City of Albuquerque Stormwater Construction Site Inspection Report

| Project Name: | Montgomery Church of Christ | | | | |
| Location: | 7201 Montgomery Blvd. NE | | | | |
| Site Contact Name & Agency | D. Mcall - midwayleasing@comcast.net | ESC File No. | F19E003A | | |

SHEET #
ESC-1

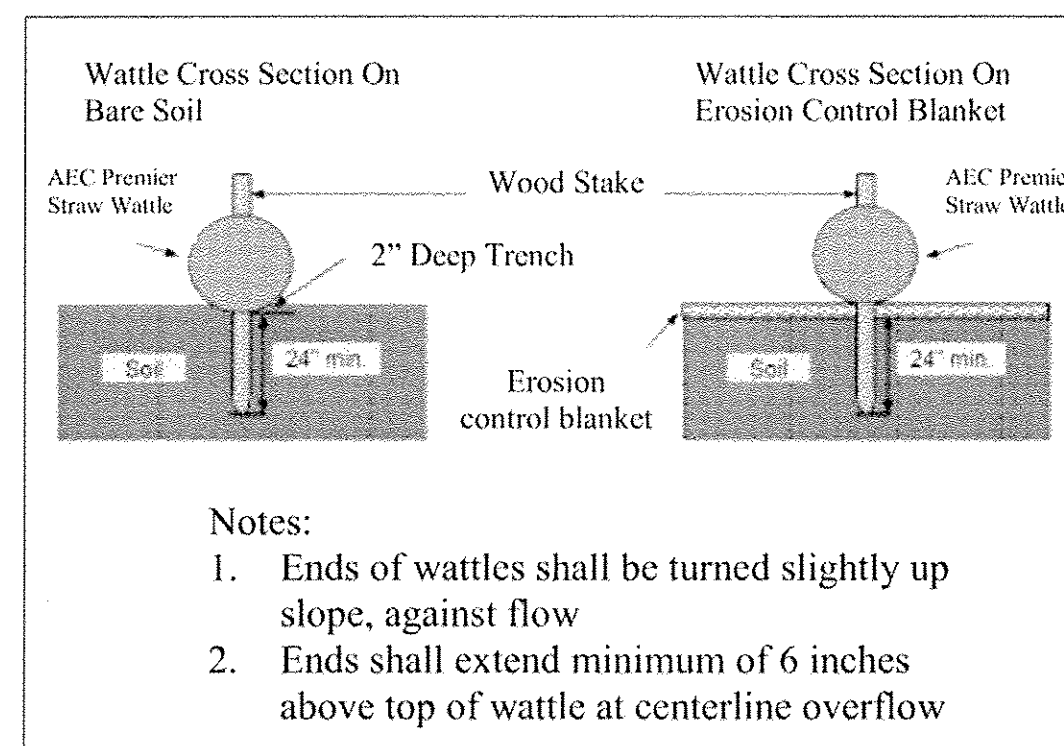
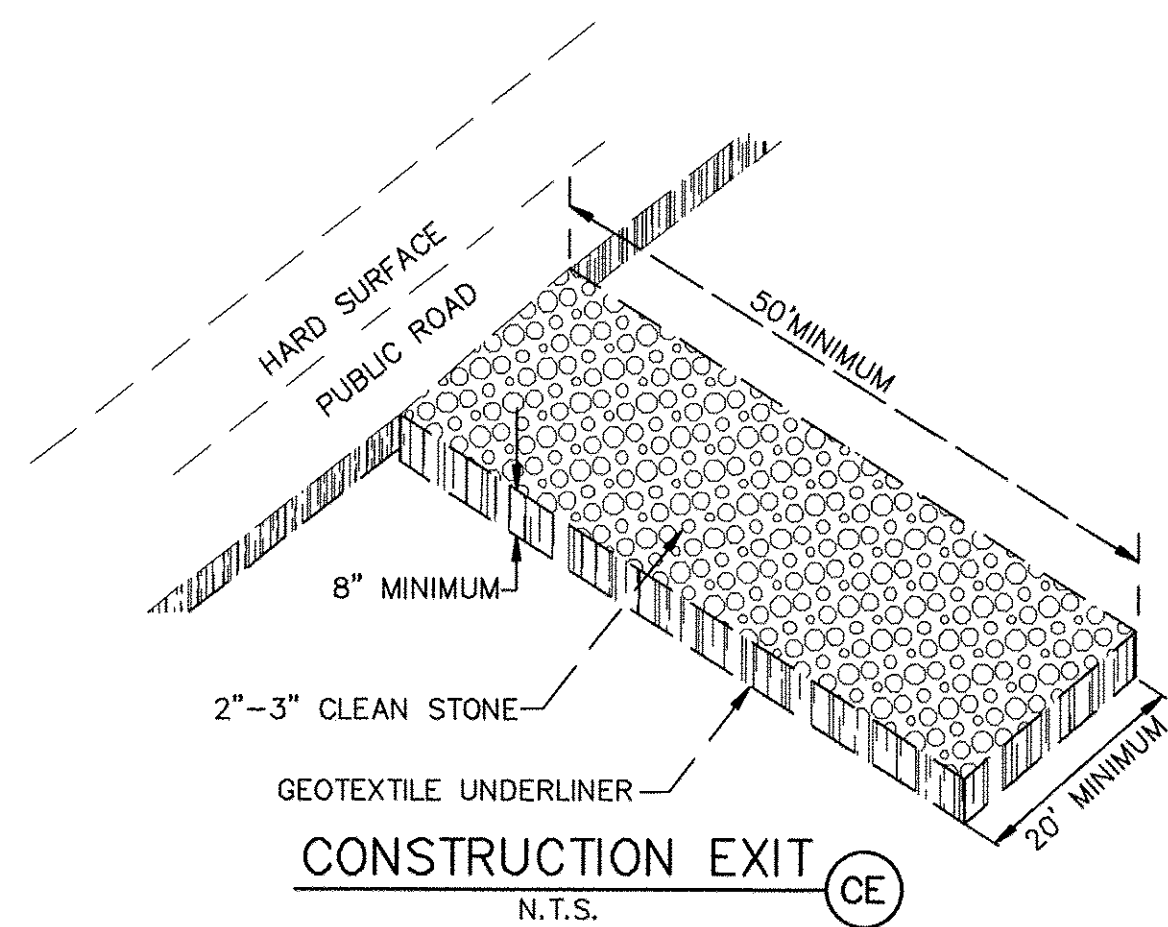
| Item Number | Deficiency/ Corrective Action | | | |
|-------------|---|----|---------------------|------------|
| 1 | Chama has sediment in street from the utility crossings for water. Please remove sediment from street. | | | |
| 2 | Coyote pumping not utilizing provided concrete washout facility. Please ensure all concrete washout is cleaned in the provide concrete washout facility. | | | |
| 3 | The storm water quality ponds on the southwest and south east should be constructed at this time to approximately the designed volume to prevent the possibility of illicit discharge from this site. | | | |
